Re: Certification Submittal for a Permanent Building Certificate of Occupancy (C.O.)
for Highland Townhomes, [L-17 / D001B]
501 Madison Place SE
Engineer's Stamp Dated 01/31/11

**Re: Madison Place Townhomes, 501 Madison Pl,
Request for Permanent C.O. - Approved
Engineer's Stamp dated: 7-16-10 (L-17/D001B)
Certification dated: 1-21-11**

**RE: Grading and Drainage Plan
501 Madison Place SE (L17-D001B)**

ENGINEER'S SEAL	MADISON PLACE TOWNHOMES GRADING AND DRAINAGE PLAN Rio Grande Engineering 1606 CENTRAL AVENUE SUITE 201 ALBUQUERQUE, NM 87108 (505) 872-0898	DRAWN BY WCUJ
			DATE 7-12-10
			2122-LAYOUT-6-29-10
			SHEET #
DAVID SOULE P.E. #14522			JOB # 2122

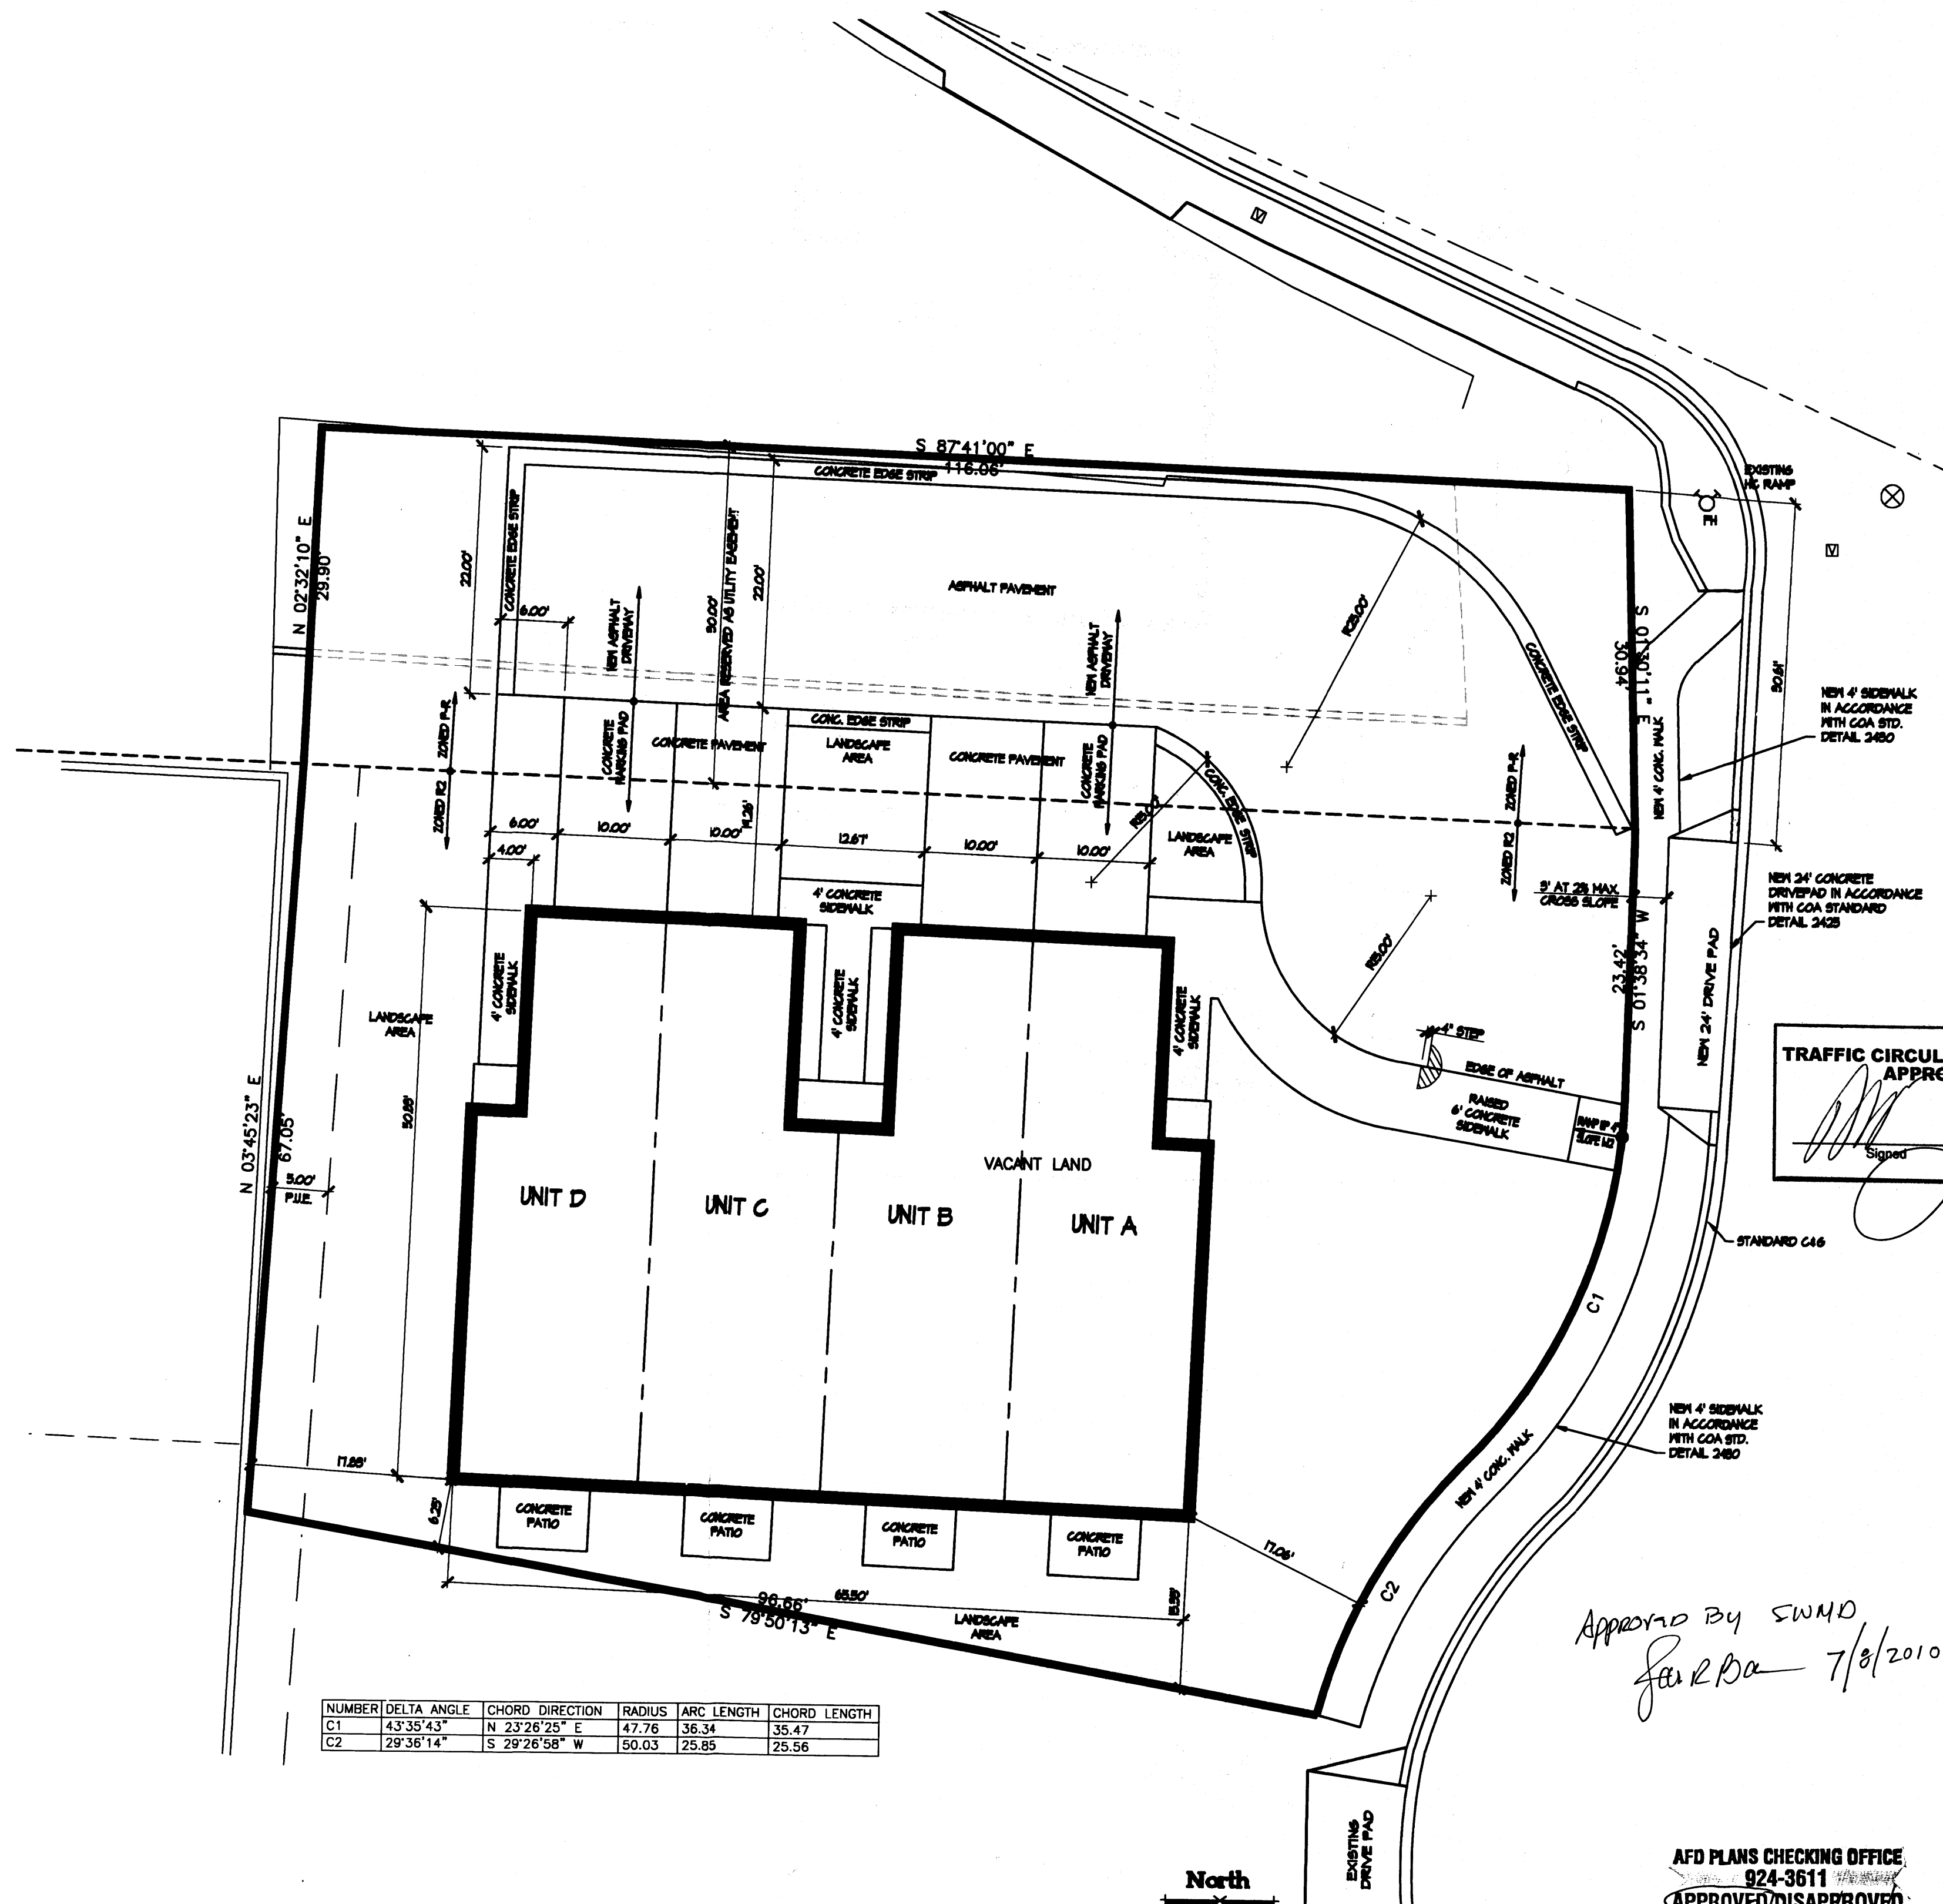
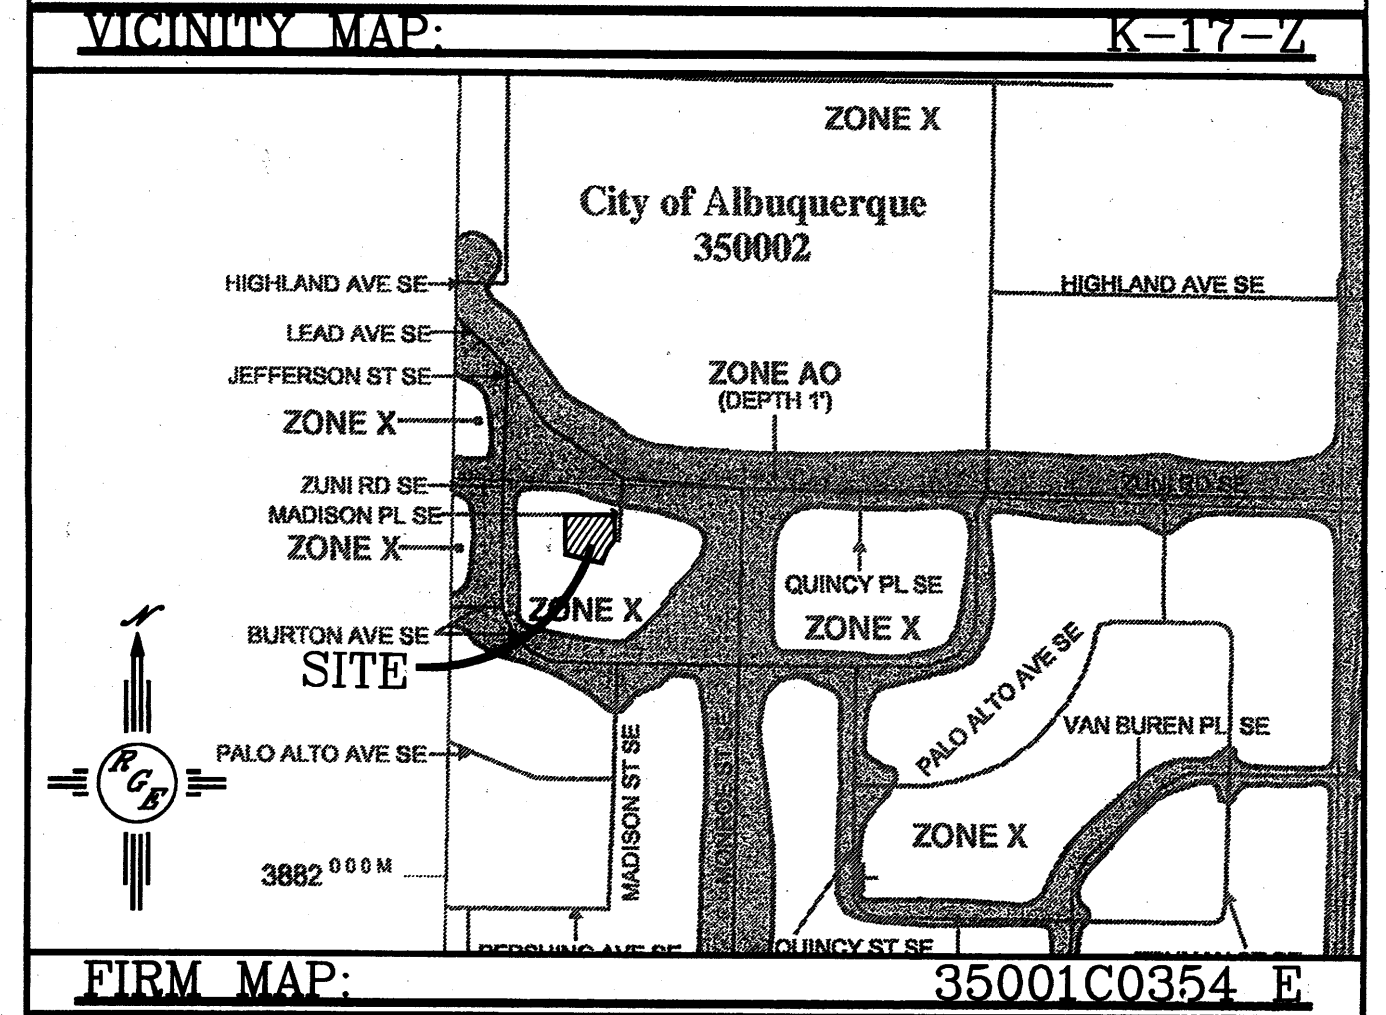
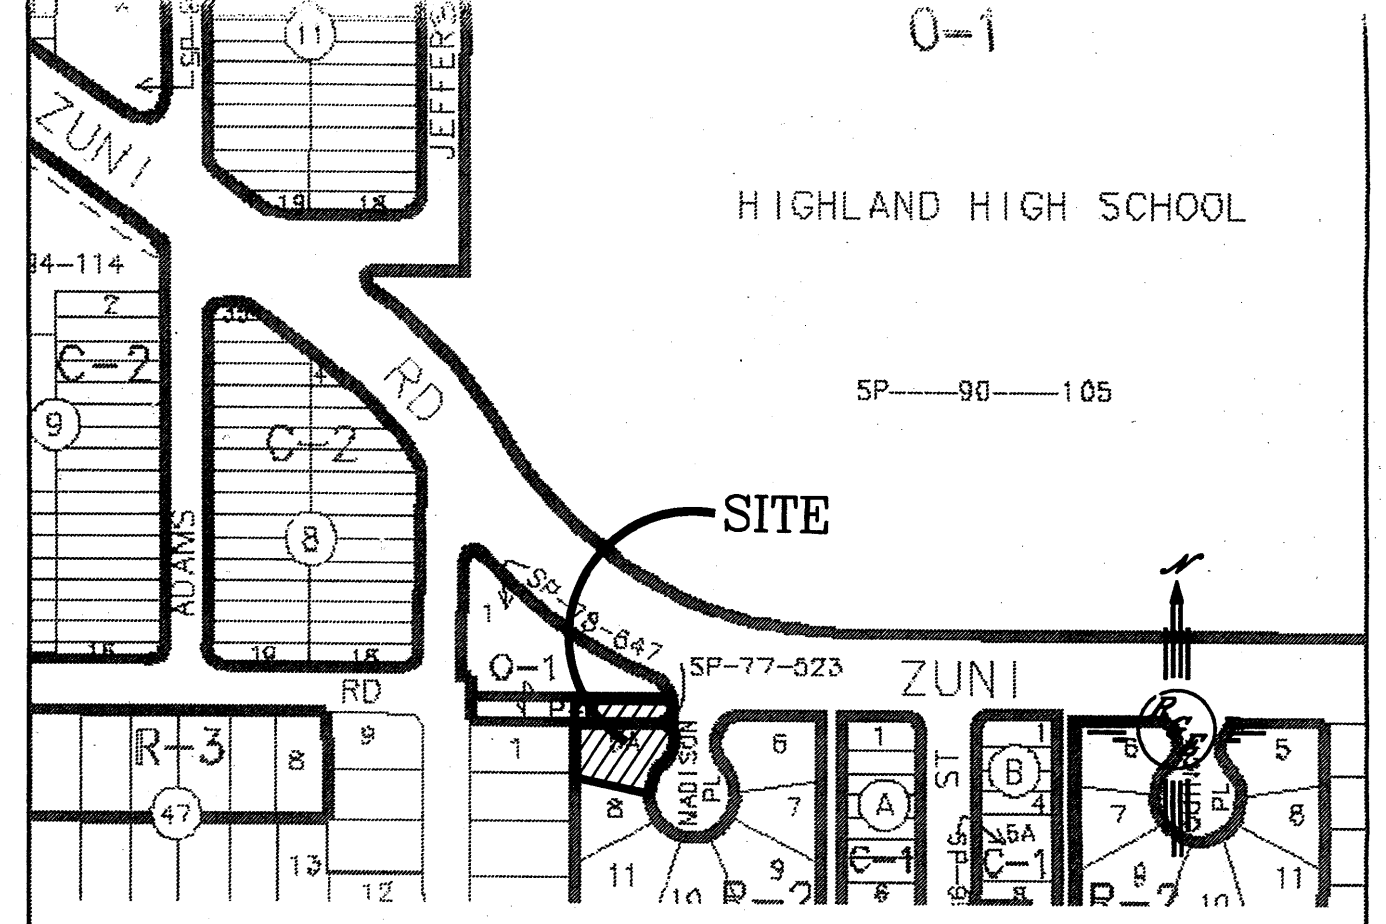
1. I would prefer for the flow to exit into Madison, unless a drainage easement agreement is received from the owners of the property to the north and west.

2. A new curb, gutter, sidewalk and drive pad need to be installed per COA specifications.

3. Build notes are needed to identify all applications

4. Please label existing and proposed contours

The site currently discharges at the location. There is not a drainage easement but a utility easement exists. Due to the slope of the land is difficult to 'buck' grade to drain to the east. We have modified the plan to drain approximately half the site to Madison. The proposed discharge to the west has been reduced to less than existing. In addition a shallow (9"deep) harvesting pond has been added to eliminate nuisance flows. The discharge point is at the half road section that continues to the west to Zuni.

The plan has been modified to clarify what is existing and what is proposed.

We have added the appropriate build notes.

We have labeled the existing contours.
